From: Sue Howell
Sent: 30 May 2017 15:21
To: Planning.Responses
Cc: Simon Davis
Subject: RE: Planning Consultation on BE/61/17/DOC

APPLICATION NO: BE/61/17/DOC

Site Address: 21 Bucksham Avenue Bersted PO21 5DT

Description of Works: Application for approval of details reserved by condition no.14 imposed on planning reference BE/60/15/PL relating to landscaping

Project:-	Proposed Residential Development 21 Bucksham Avenue Bognor Regis West Sussex		
Title:-	Proposed Landscape Plan (Part 2)		
Client:-	Shopland Gray Developments Ltd		
Scale:-	1:100 (@A1)		
Drawn By:-	PJD	Checked By:-	PJD
Date:-	28/04/17	Date:-	28/04/17
Job.No:-	120096	Drg.No:-	31
		Rev:-	A

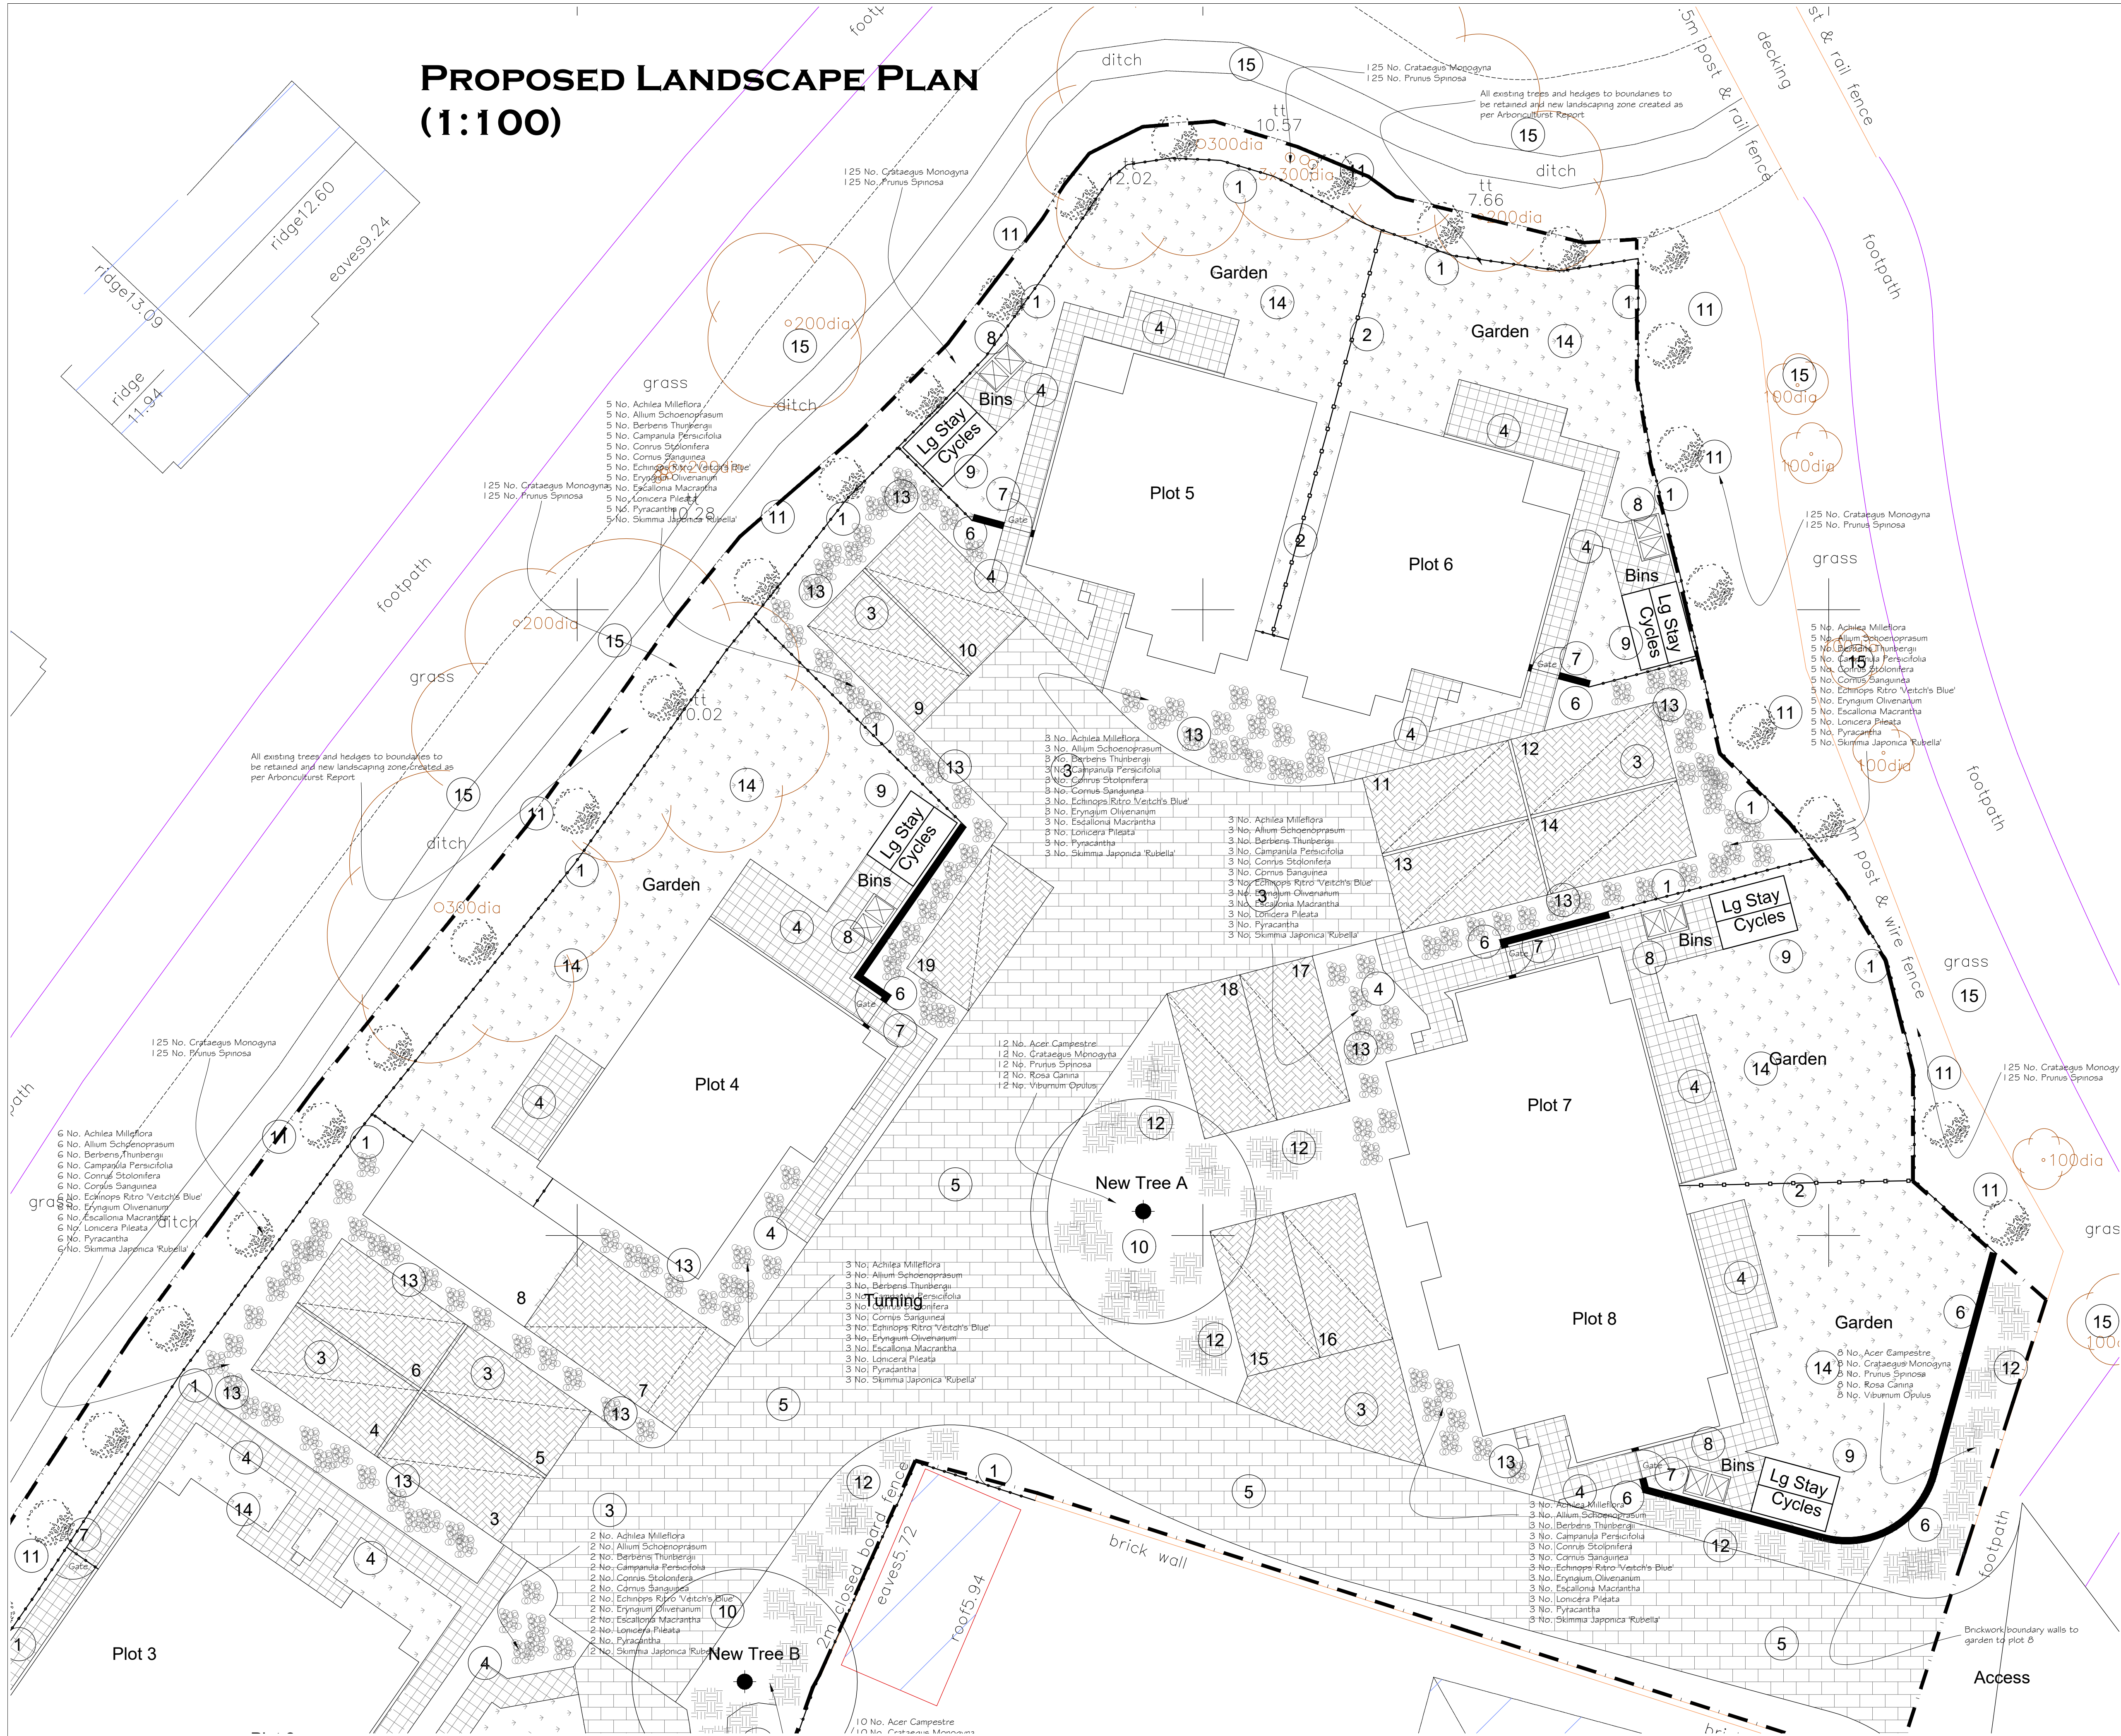
The Drawings submitted under application BE/61/17/DOC Proposed landscape Plan 120096 31 28/04/17 2 of 2 provide good detail regarding species choice being proposed, however these drawings need to detail actual numbers being proposed rather than just planting densities. We would request that this information is submitted for approval therefore we would not recommend the discharge of Condition 14 landscaping on application BE/61/17/DOC imposed under BE/60/15/PL until this additional information is submitted and approved.
